From: N Moss [REDACTED]
Sent: 14 October 2013 14:00
To: Janice Chapman
Subject: RE: Y/54/13/L - Replacement of 9 windows at Bonhams Farmhouse, Main Road, Yapton

Description of Works: Application for Listed Building Consent for removal of 9 No existing rotten sash windows and replacement with 9 No new purpose made box sash windows.

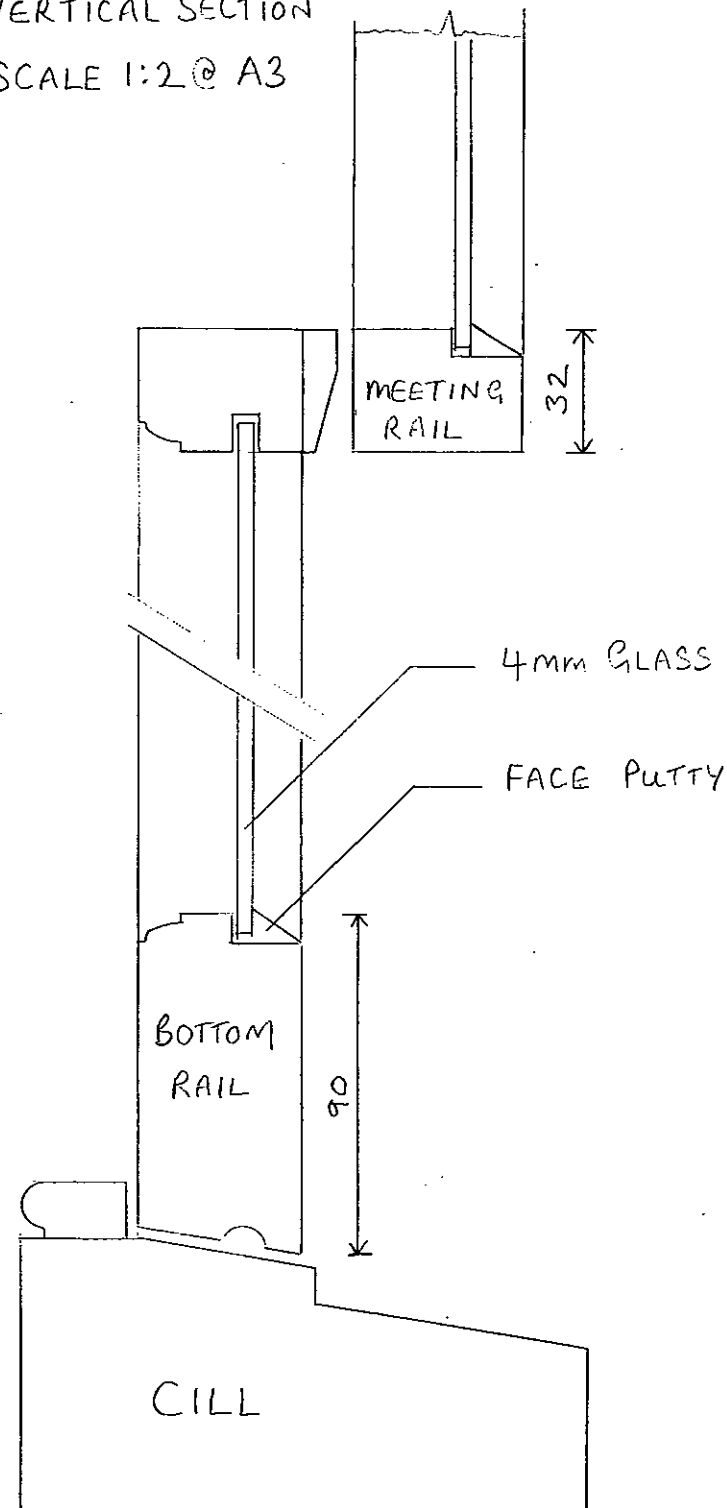
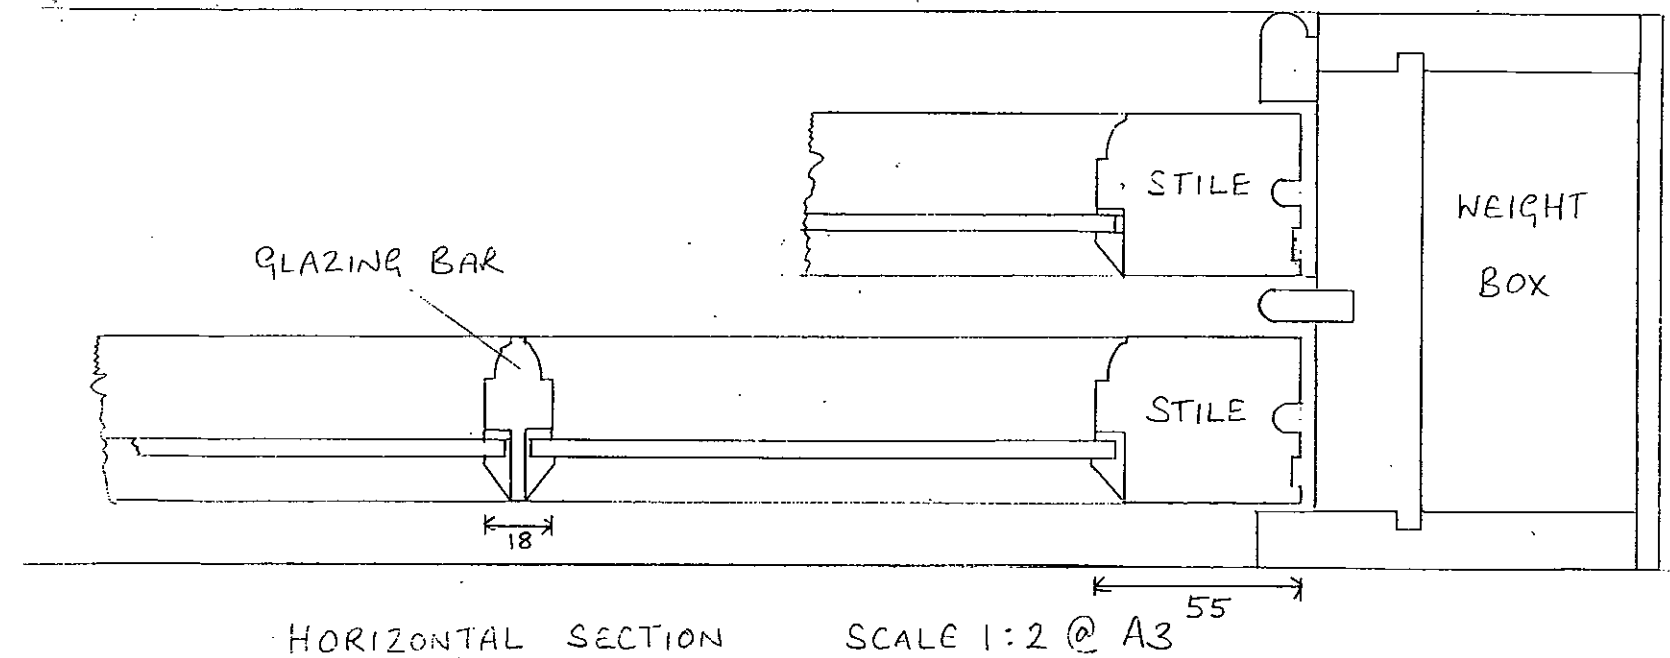
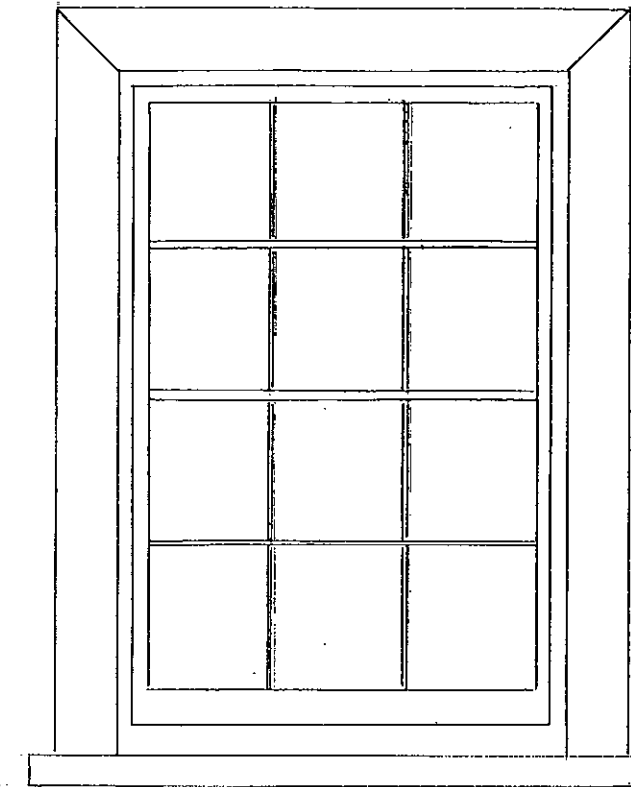
I attach comments from the Historic Buildings Adviser regarding the replacement windows. Can you advise if you are willing to revise the change in design of windows (like for like) relating to W6, W7, W8 and W9 on the later single storey addition.

There has been a miscommunication at my end. Having discussed the matter with the specialist joiner contracted to carry out the work it appears that windows W6 through W9 are only in need of general maintenance and decoration and will not be replaced. Consequently the differentiation between the later addition and original building will remain.

At the present time we are not sure if any crown glass remains in the original windows. However, when work commences a through inspection will be carried out and any crown glass will be salvaged and fitted in the new frames.
